## **Greater Dublin Drainage Project Addendum**

Appendix A13.5 – Responses to Traffic and Transport Questions at the 2019 Oral Hearing

**Response to Inspector's Questions**

Response to Roads Issues Raised on behalf of Gannon Properties and Response to Roads and Traffic Issues Raised by Sabrina Joyce Kemper

Title: **PROPOSED CULVERT AT MAYNE RIVER CROSSING - WWTP ACCESS ROAD - SHEET 1 OF 2 -**

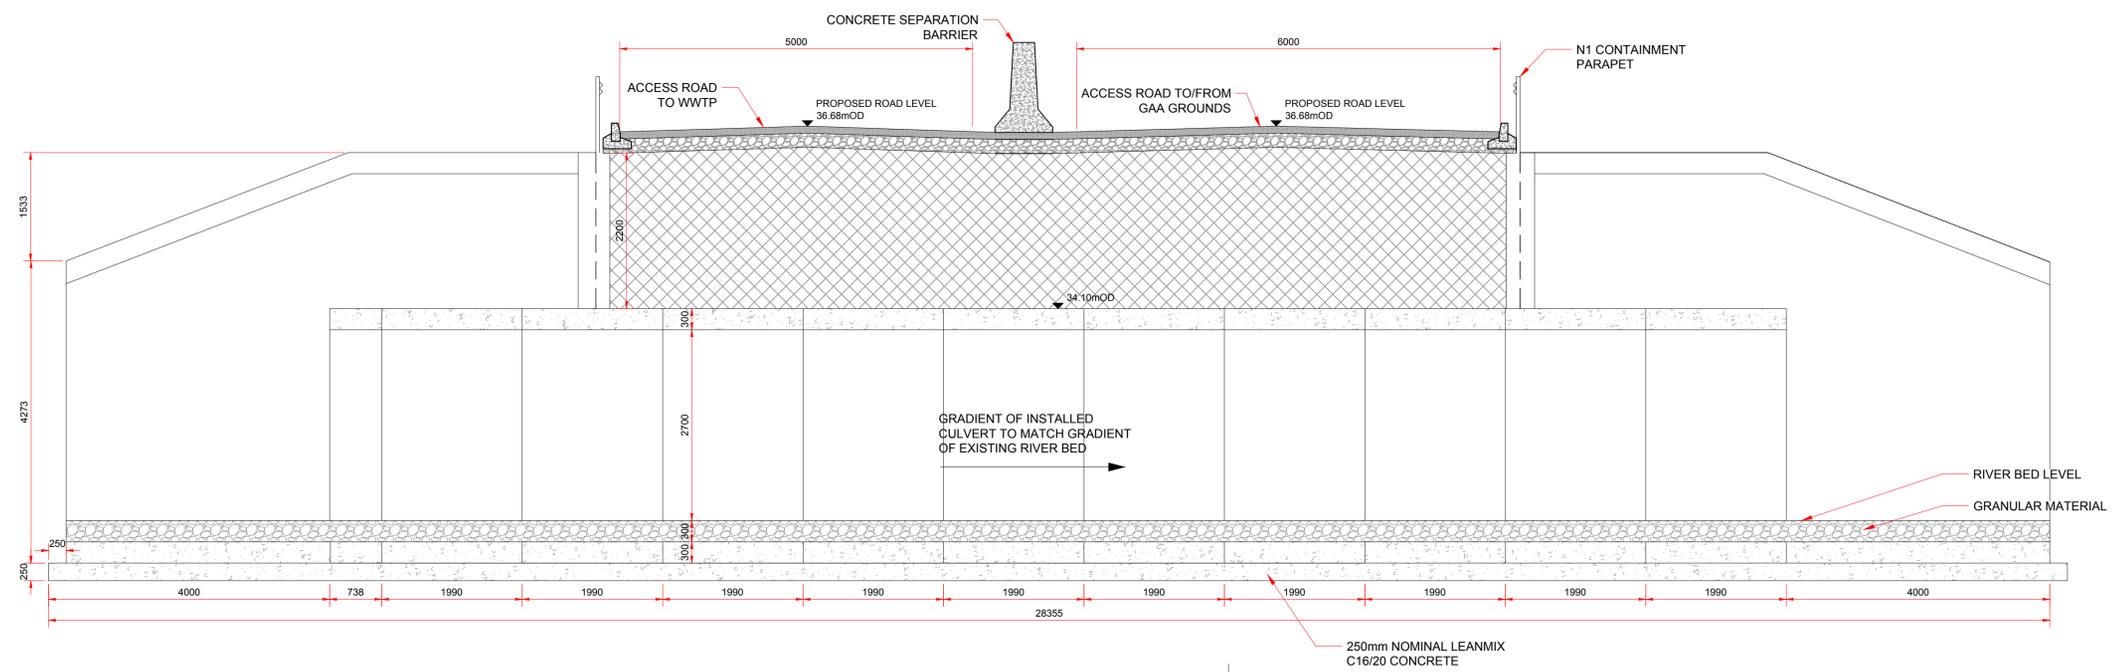
- 11 The observer has stated the applicant be conditioned to construct the Mayne River Culvert to the distributor road standard.
- 12 I can confirm that the application for the Proposed Development includes the construction of the Mayne River Culvert to facilitate both the proposed one-way WwTP Access Road and the adjacent Craobh Chiaráin GAA club access road proposals. This is shown as the blue hatched area on drawing 32102902-1067 included with Appendix 2 - Appendix A Part 2 of the Construction Environmental Management Plan.

- 13 The length of the proposed Mayne River culvert shown on Planning Drawing 32102902-2148 will also facilitate the indicative cross section of the FCC future North South Link Road (i.e. 17.5m wide back of footway to back of footway, comprising 2m footway, 1.5m on road cycle lane, 3.5m northbound traffic lane, 3.5m reserve / turning lane, 3.5m southbound traffic lane, 1.5m cycle lane and 2.0m footway).
- 14 It is acknowledged that as the future North-South Link Road cross section is indicative, the future road width may be subject to change as the development plan is advanced. Should a wider future road cross section be required, the culvert can be widened by removing the eastern headwall and extending the culvert units the necessary additional width.
